Response to Submissions

Shore Physical Education Centre

Prepared for Shore School c/o epm Projects / 19th December, 2016

**Shore School Physical Education Centre (SSD 7507)
Response to Submissions**

01 SECTION THROUGH CAR PARK & COOLING TOWERS  
4090 1:200 @ A1

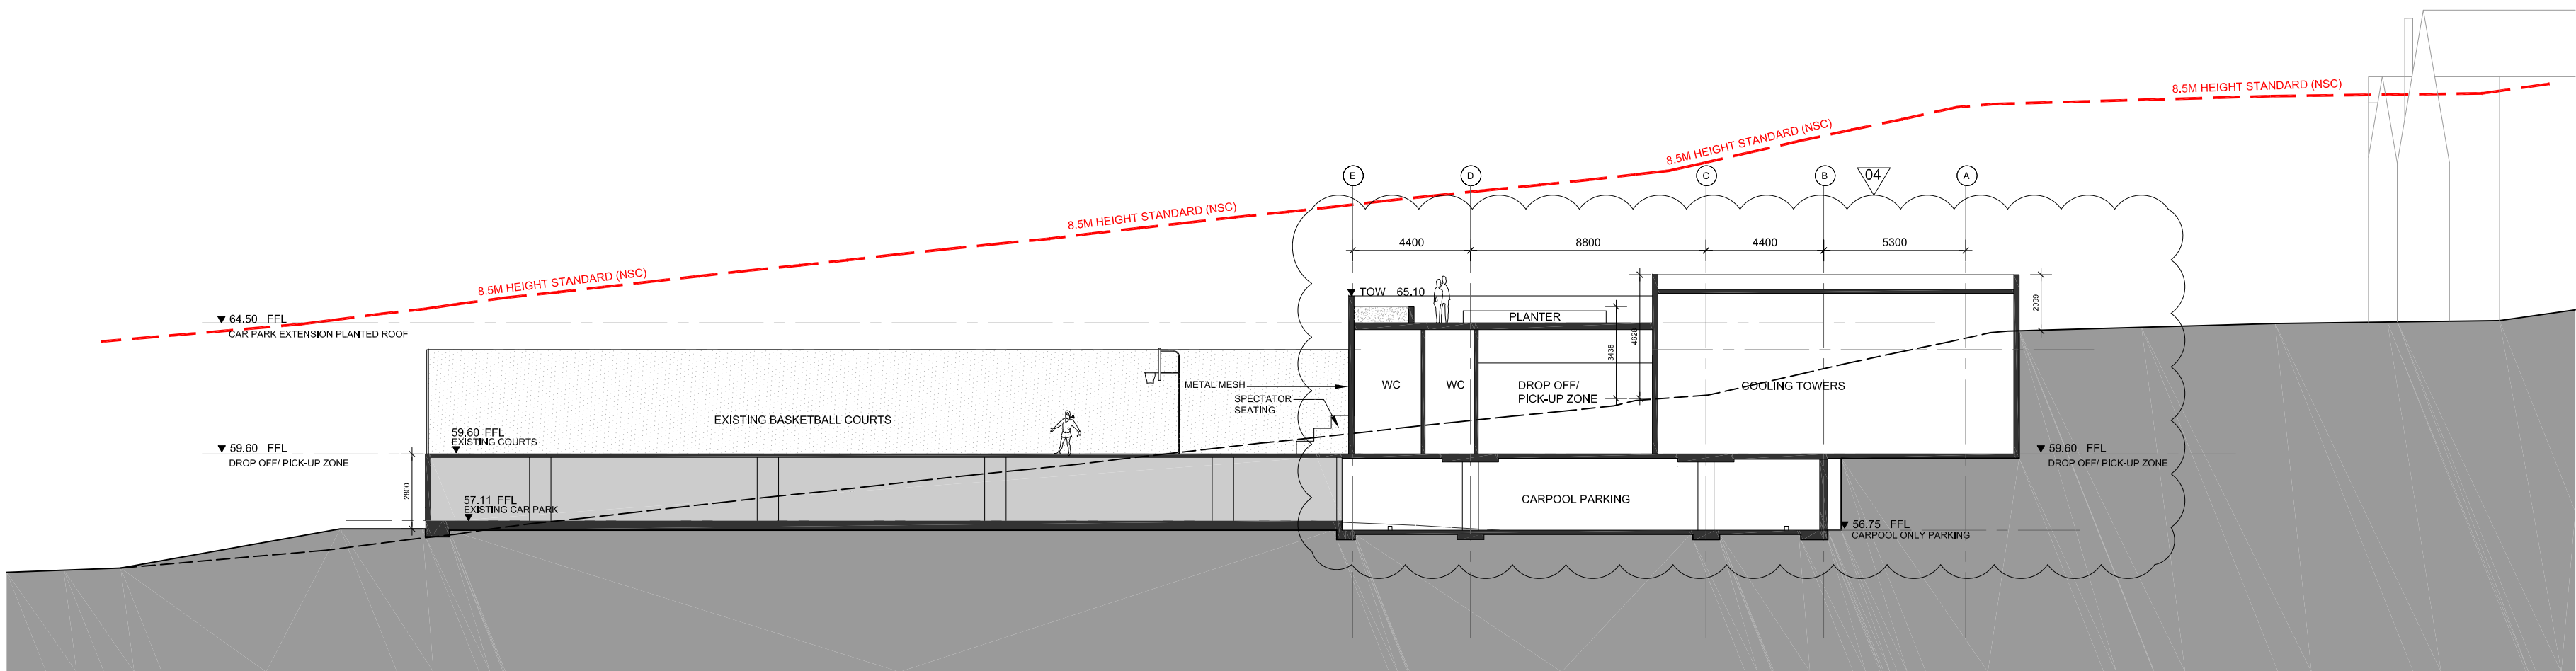
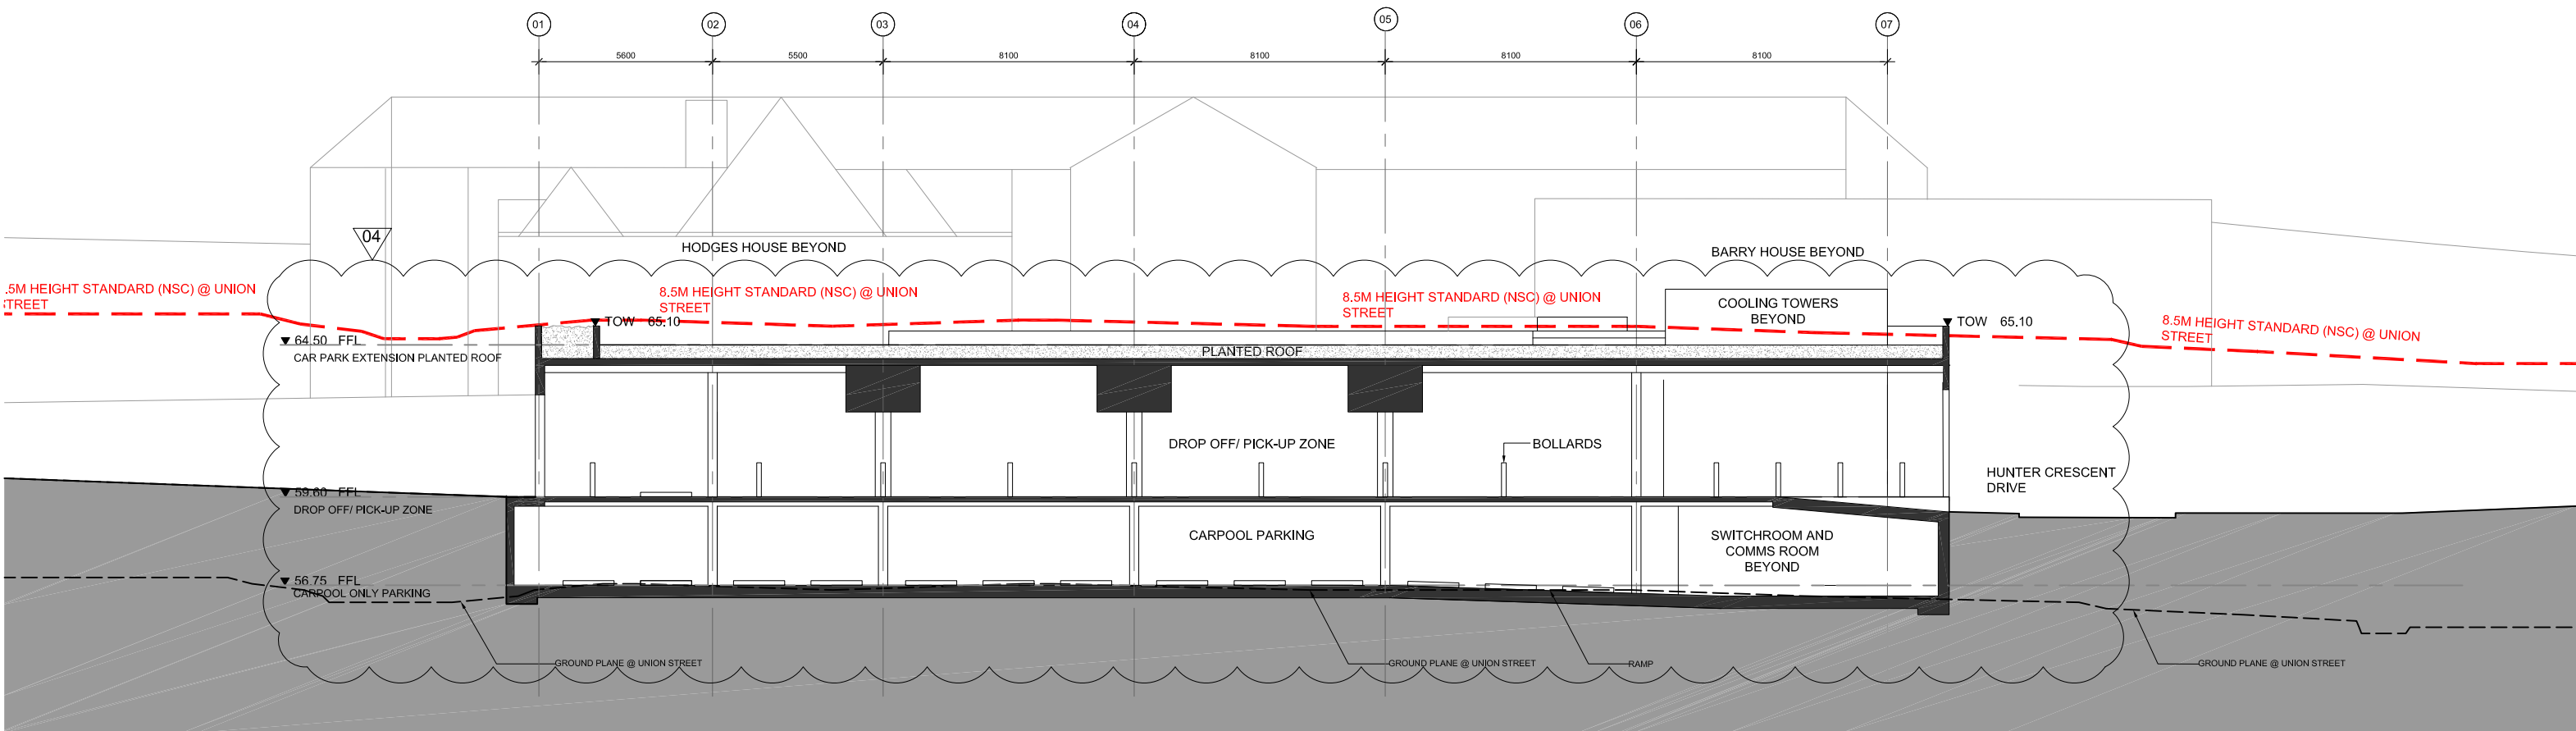
The existing parking provisions already significantly exceed the maximum requirements set out in the North Sydney DCP 2013 (269%). The development proposes an additional 38 parking spaces above the existing provision, which will further exceed the maximum requirements set out in the North Sydney DCP 2013. This is 338% of what is permitted under the DCP.

It is strongly recommended that the car parking provision be reduced to comply with the limits set out in North Sydney DCP 2013.

Parking in the SPEC basement area is to be used as a loading area only, and has now been reduced to 6 loading spaces. Revised architectural plans from Cox Richardson (A-DA-2190 and 2191, dated 01/12/16) indicate that the expansion to the Bishopsgate Car Park has also been reduced by 6 spaces (with the originally proposed 54 spaces being reduced to 48).

There is a net increase in total provision of 25 spaces, as a result of the addition of 48 spaces in the Bishopsgate Car Park and relocation of 23 spaces along the driveway. These spaces will be available for contractors, volunteers, and visitors, and also loading areas. The parking provision at Shore will be a total of 173 spaces.
